Cockle Bay Park – Response to Agency Submissions

7.5 Visibility – after 60 minutes

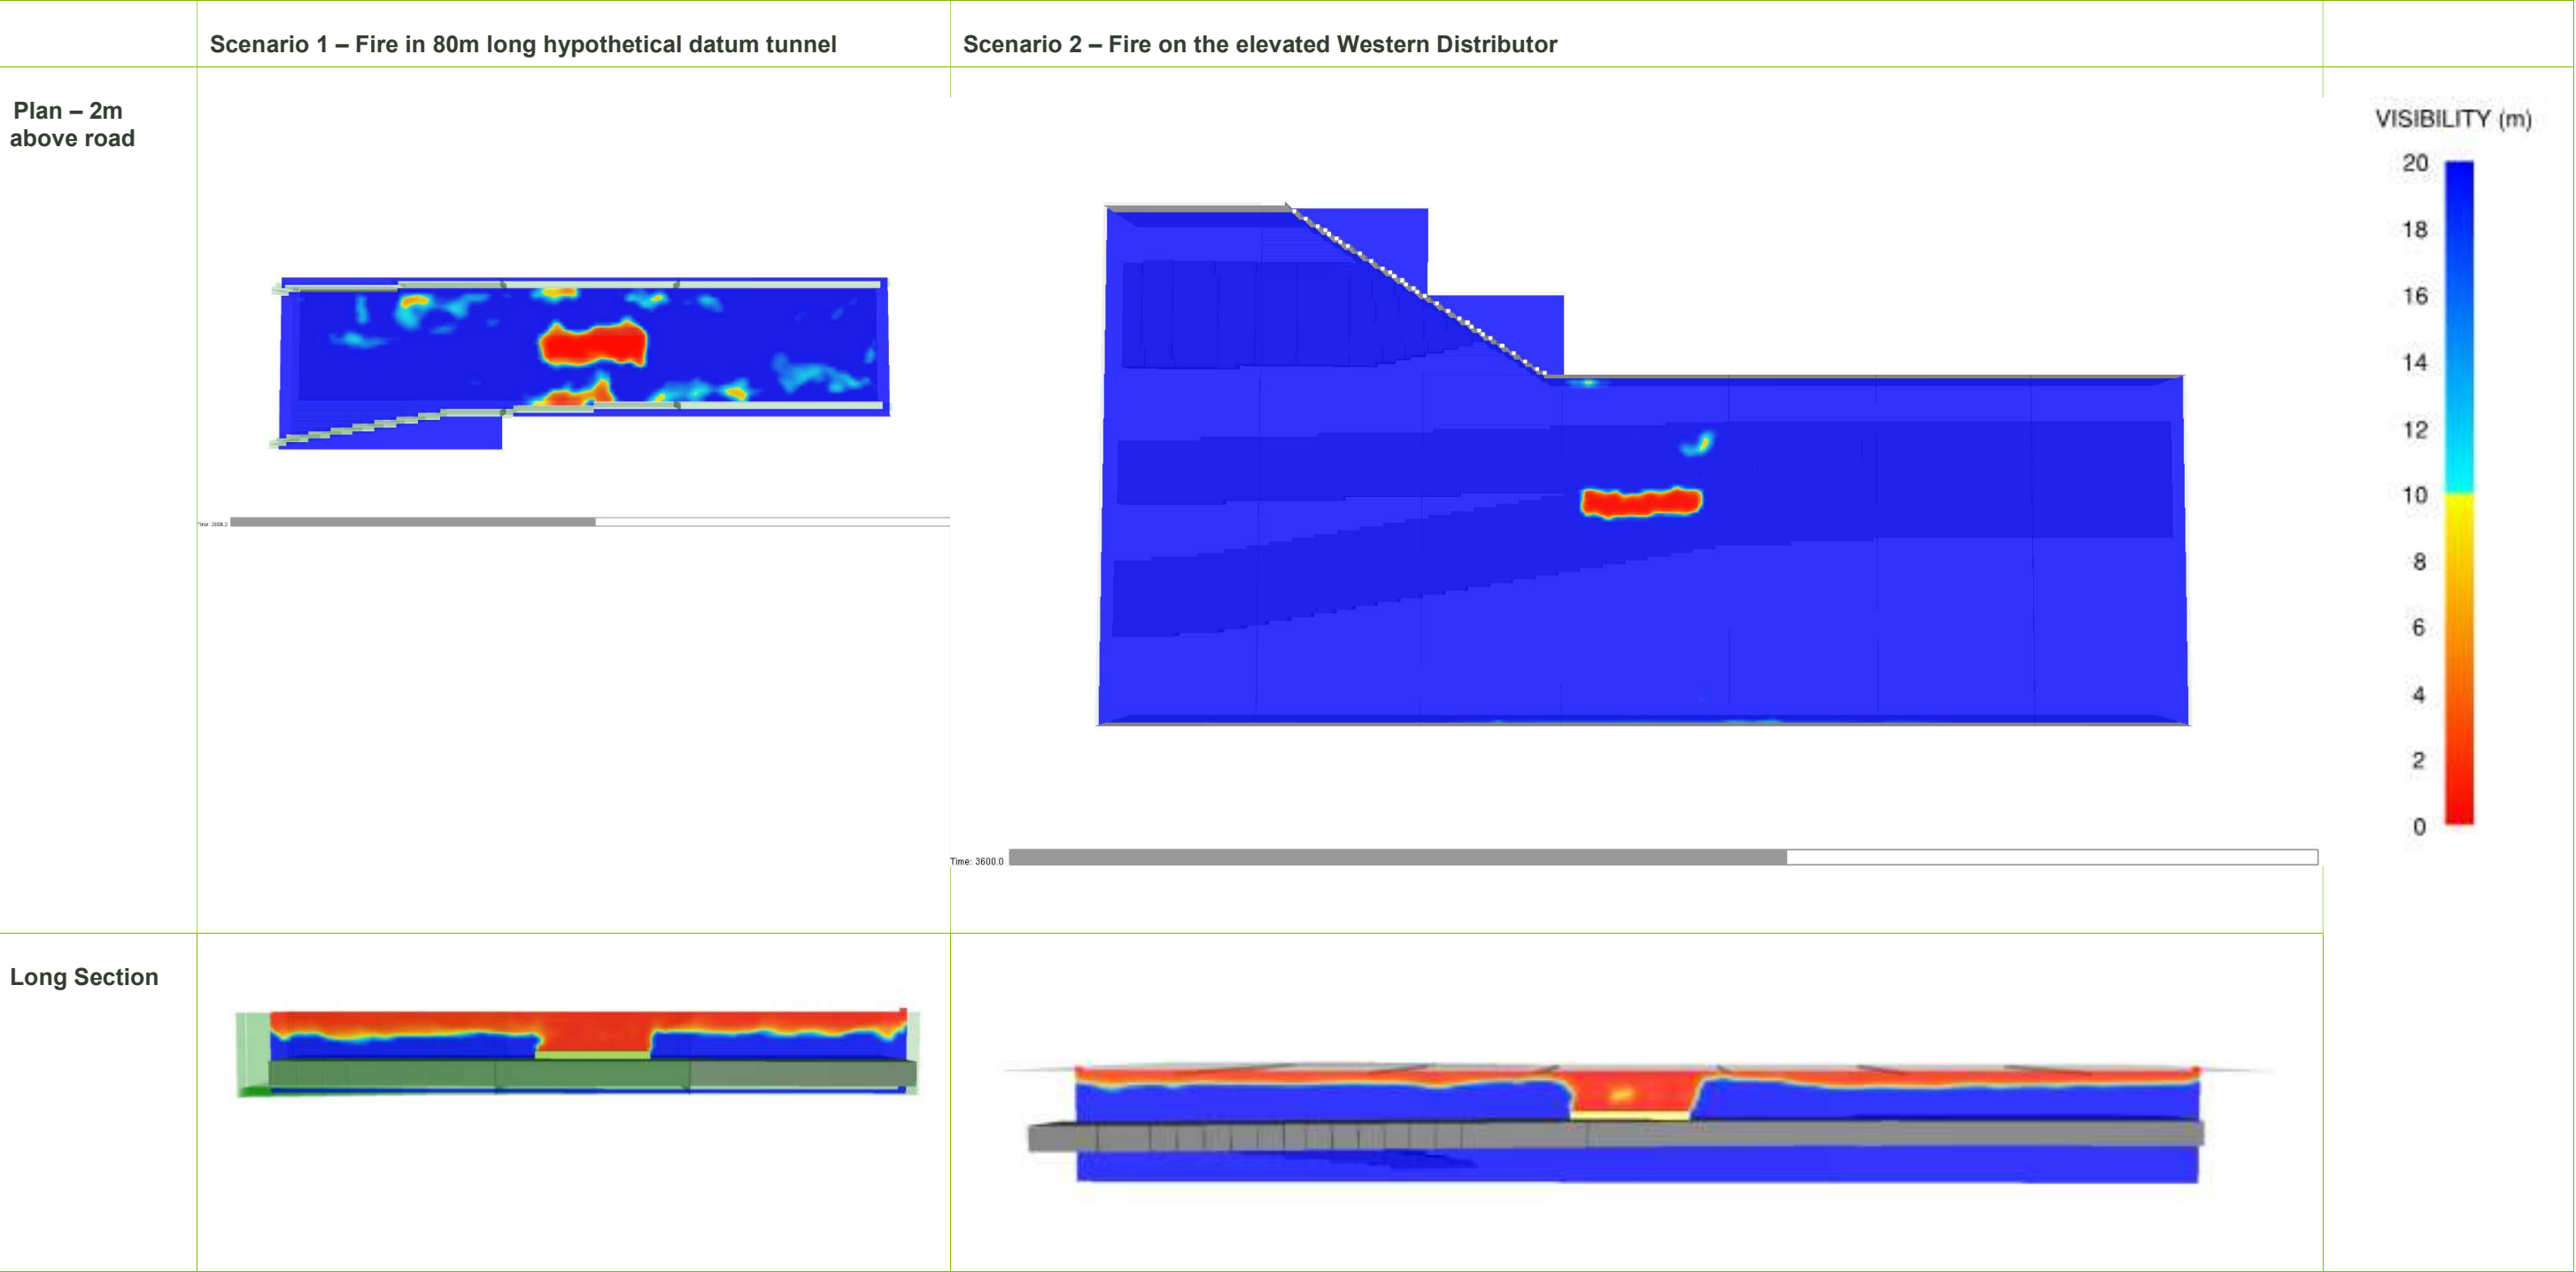
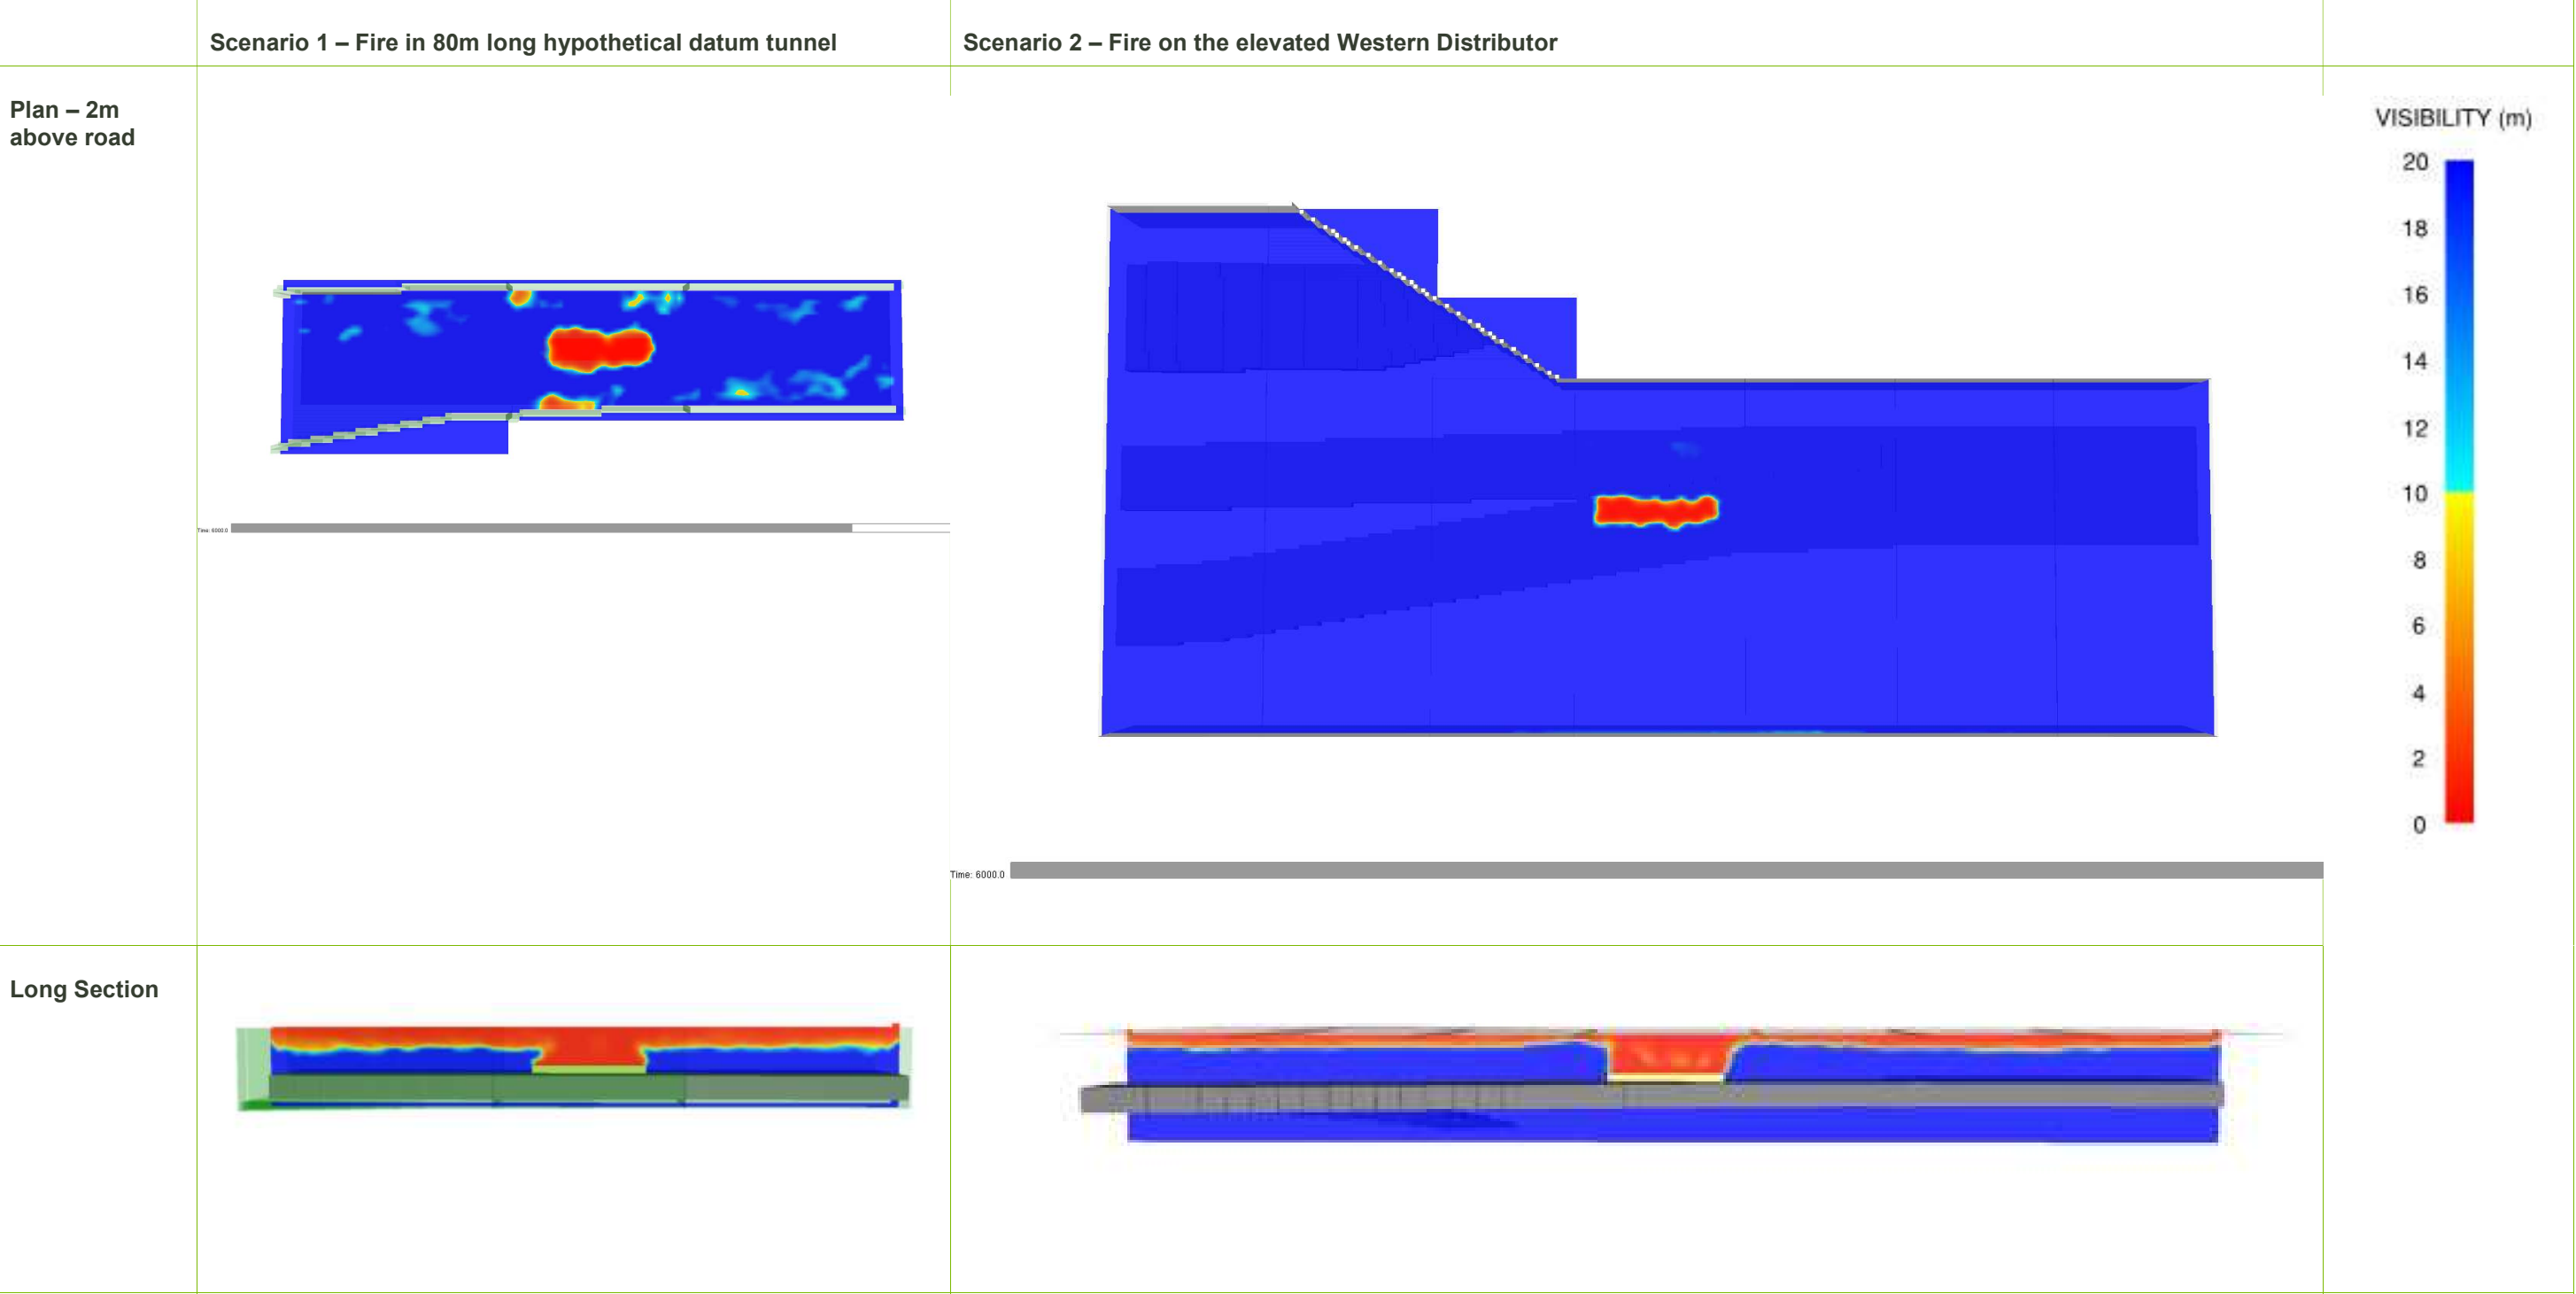
<p>Fire safety – the proposal has the effect of creating a tunnel underneath the podium – adequate provision of fire safety must be provided regarding traffic flow</p>	<p>Fire safety design criteria regarding the Western Distributor as it travels under the landbridge have been developed by Aurecon, in consultation with RMS (refer to Appendix J1). The design criteria are to be implemented at the relevant future stages of detailed design to ensure adequate fire safety provision is achieved.</p>
<p>Piering Options – RMS has request no piers in addition to the proposed piers option</p>	<p>Enstruct and Aurecon have considered structural options for landbridge pier locations including piers between on-grade northbound Harbour St and the elevated Western Distributor and an alternate 'no piers' option. The options are presented at Appendix K and Appendix W (refer to Section 7.20 of the</p>
